CM/45/19/PL

The site subject to this application comprises two barns which, whilst not statutorily listed, have been identified as a non-designated heritage asset by the authority. I note that a previous application on the site was granted permission in 2018.

The current application relates to a number of amendments to that previously approved scheme. These changes are both internal and external.

| Rev.                                                                                                                                                                                                                                                           | Notes             | Date     |
|----------------------------------------------------------------------------------------------------------------------------------------------------------------------------------------------------------------------------------------------------------------|-------------------|----------|
| Drawing No.<br>P02 - P3                                                                                                                                                                                                                                        |                   |          |

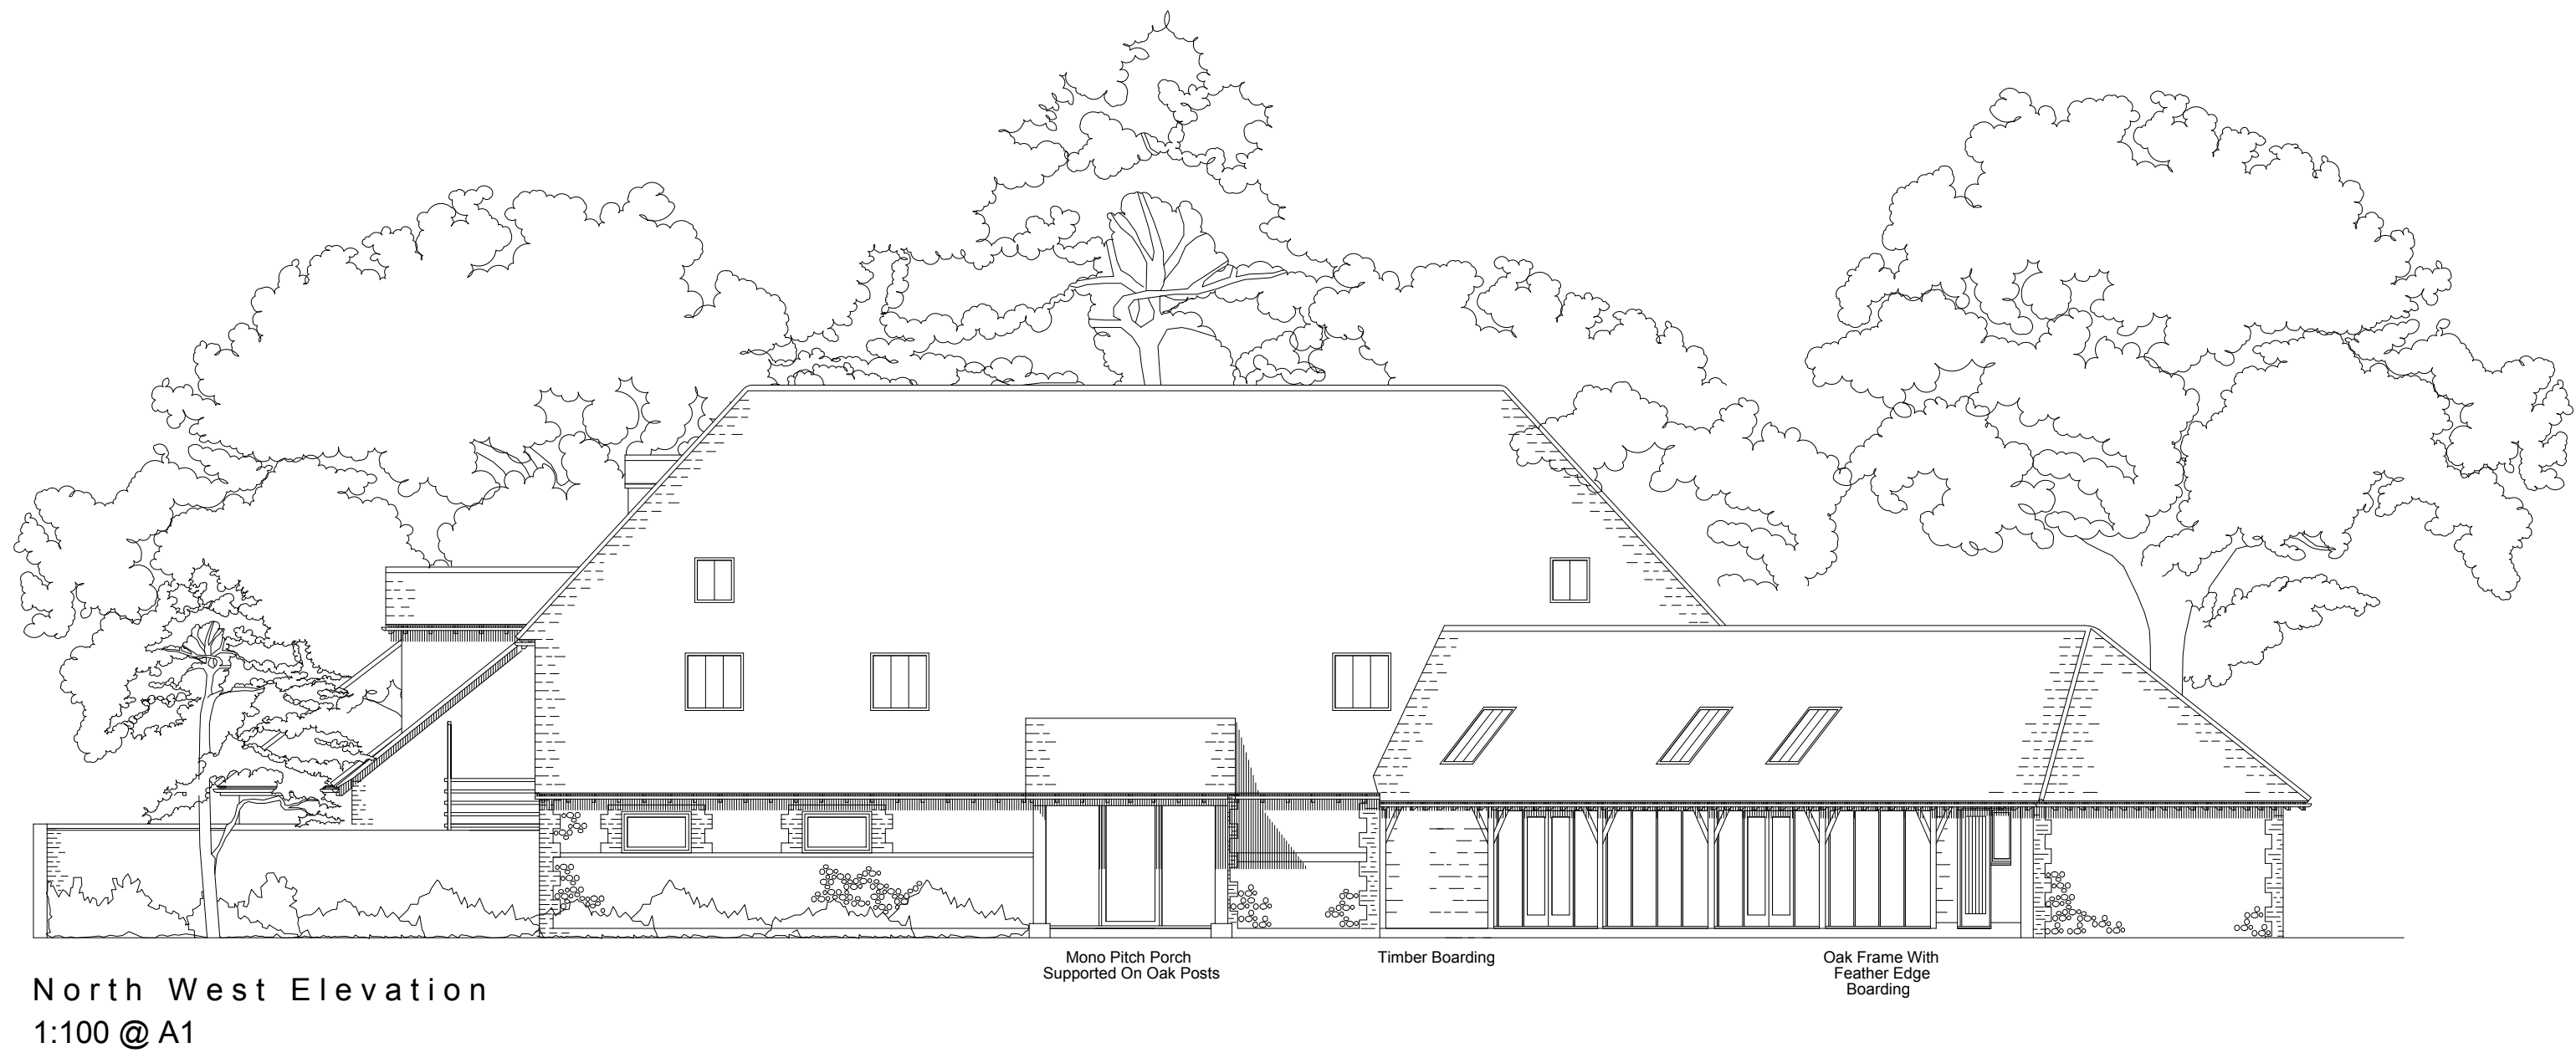
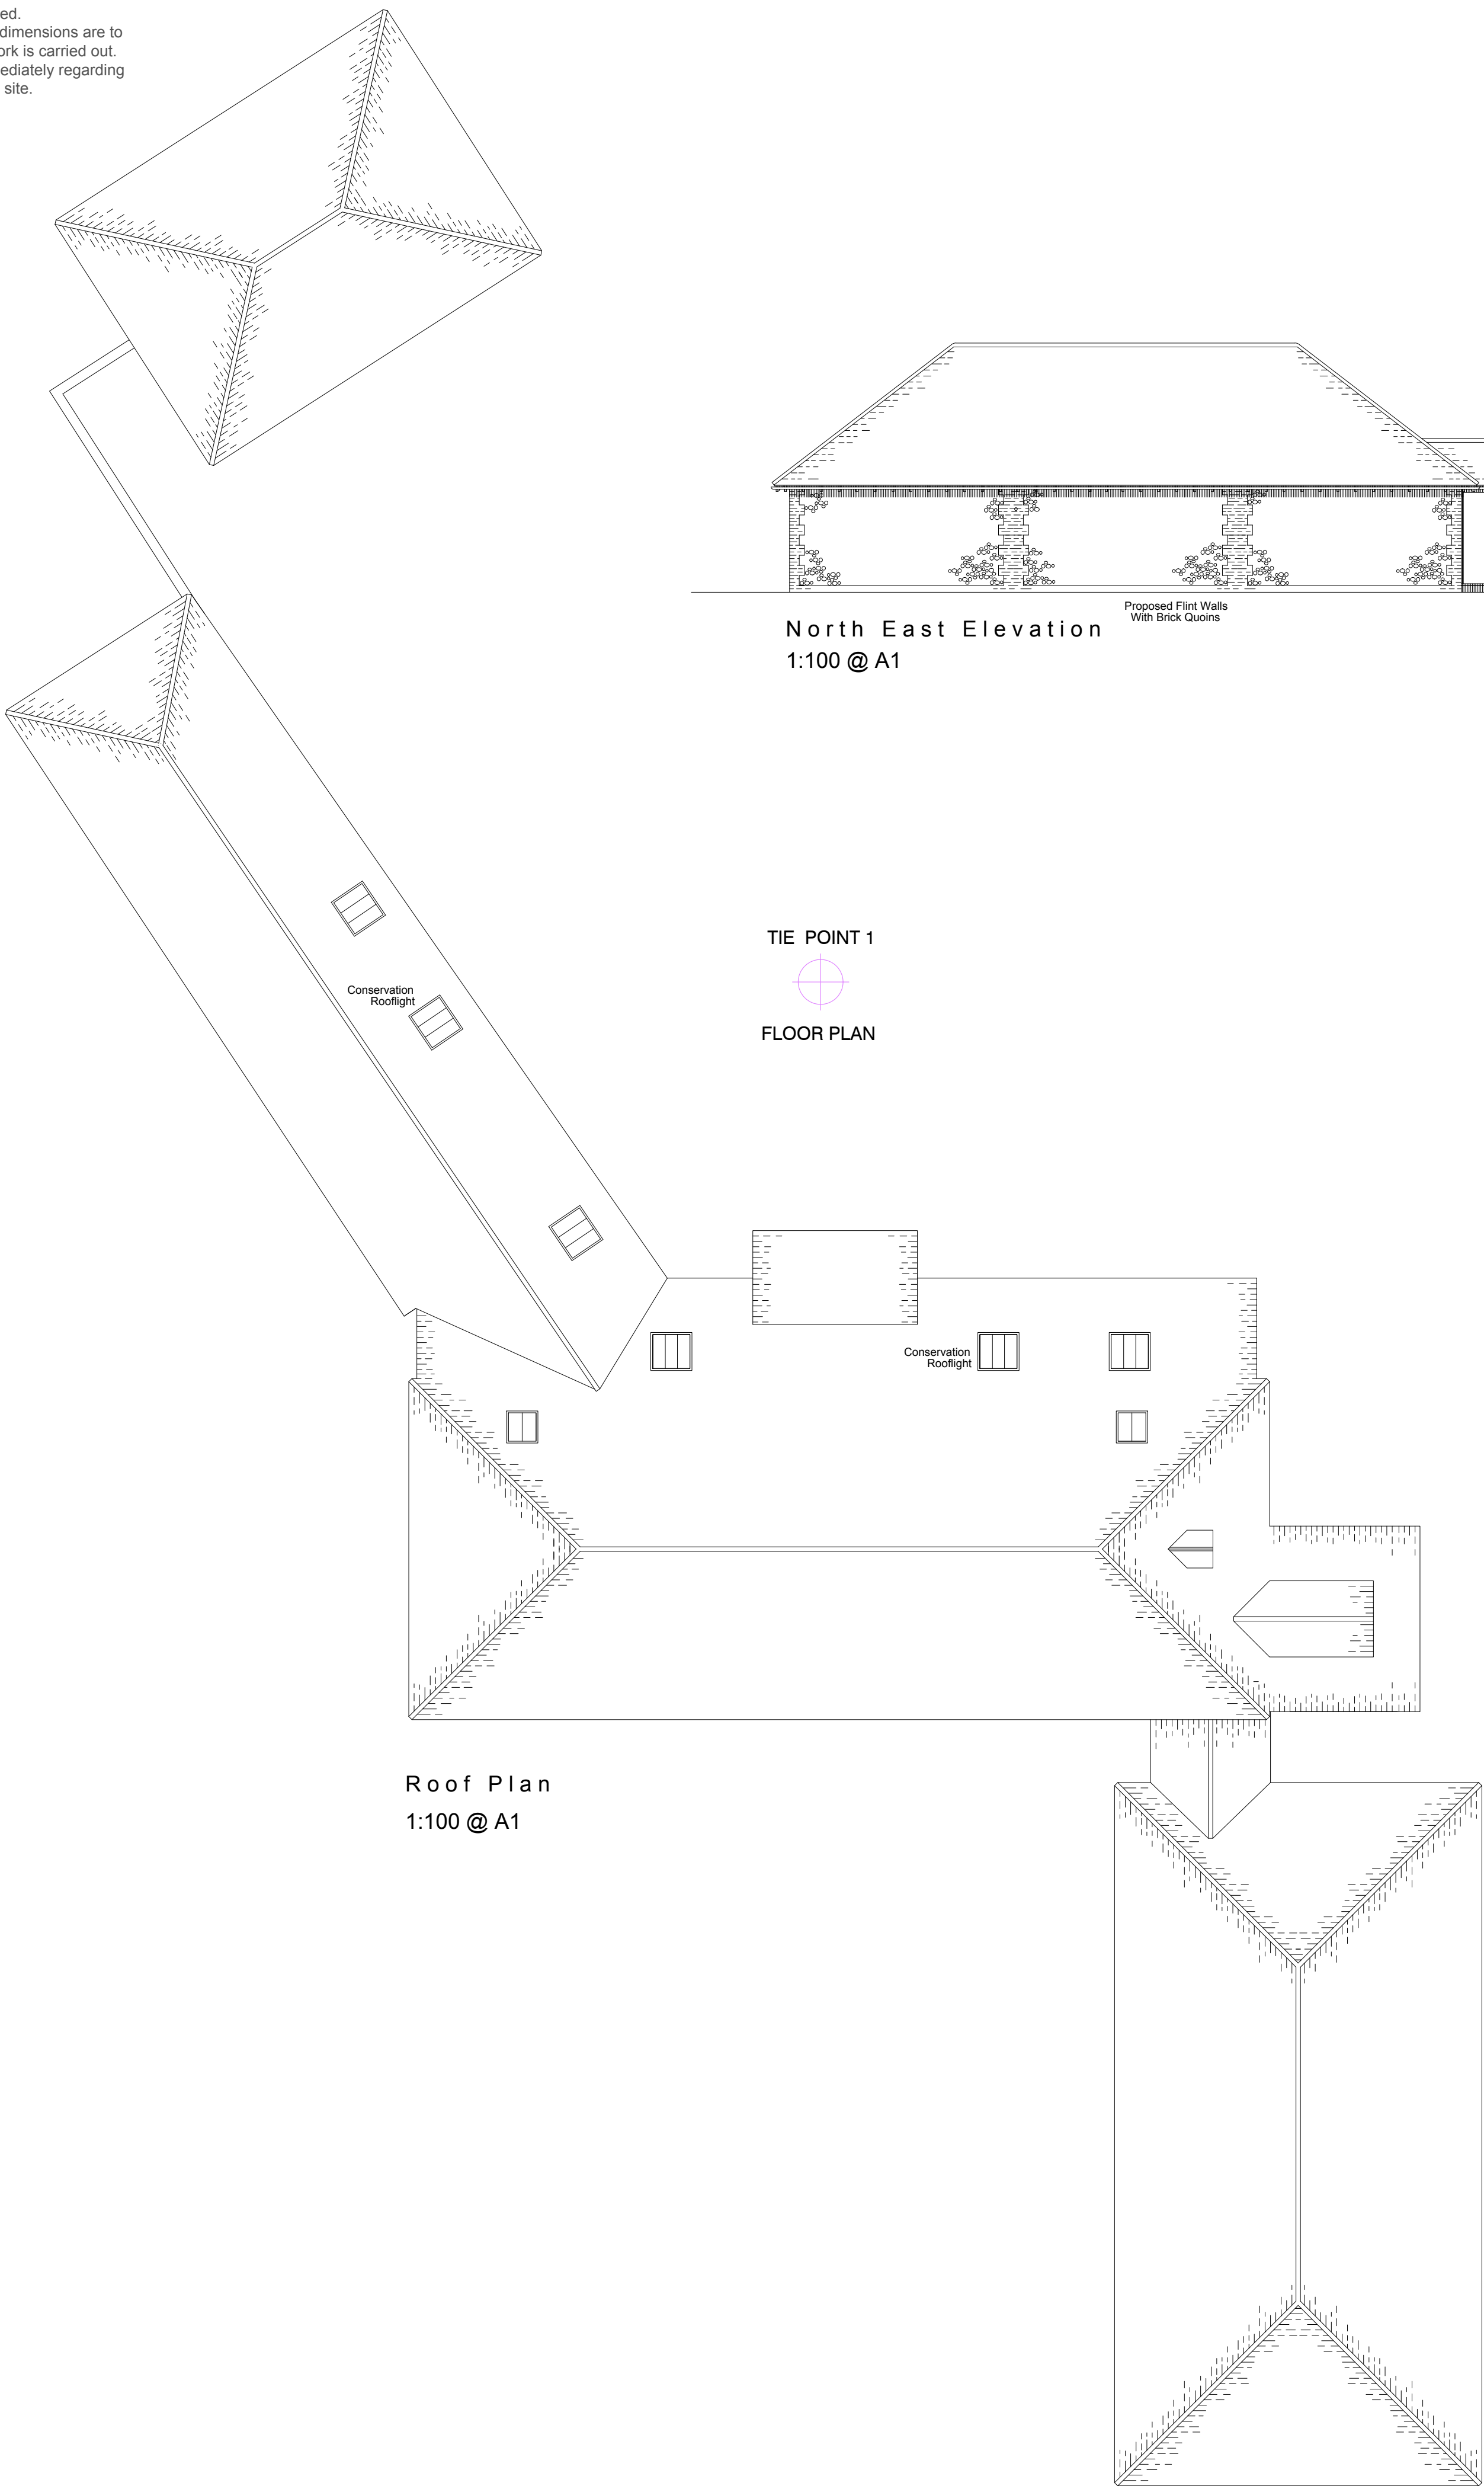
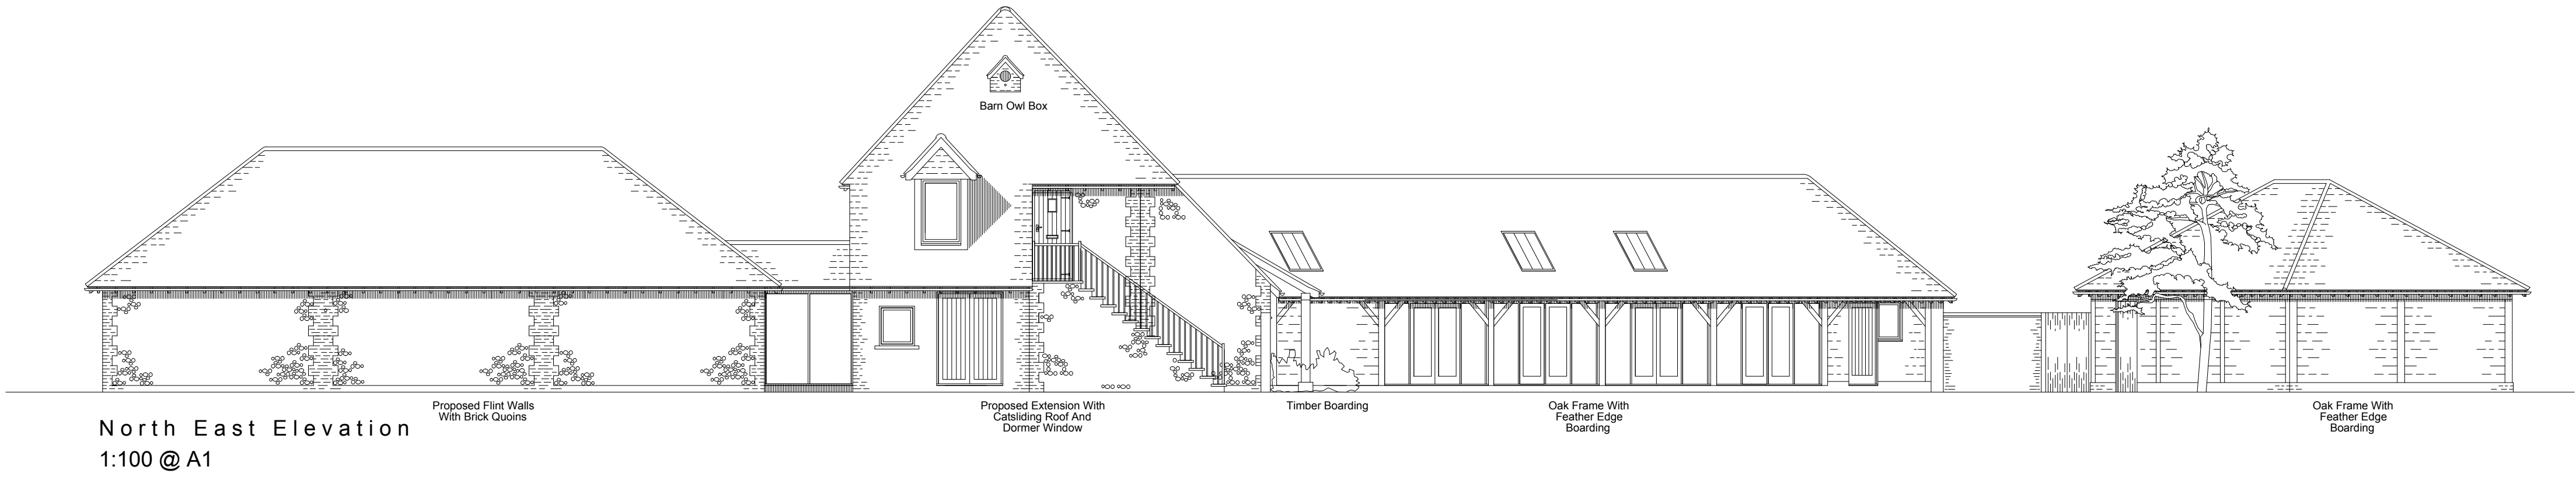
Minor alterations are proposed to the conservation roof lights which include the relocation of a limited number of units, enlarging one existing unit, and introducing an additional one (on the north-west elevation). I have had the opportunity to compare the proposed plans with the approved ones, and do not consider that these amendments are harmful.

Likewise, the introduction of a traditional brick and flint granary stairs to create a back entrance to the proposed first floor Kitchen and Living would not harm the character of the building. It is therefore considered to be acceptable. If minded to approve the application, you may wish to request details of the railings and the flint/brickwork in order to ensure that they are appropriate for the building.

I also note from comparing the proposed plans with those within the approved planning application, that the three windows on the south-west elevation, and two windows on the south-east elevation have slightly increased in size. Whilst they are larger in size, it is thought that they do not alter the character of the building significantly enough to raise any concern.
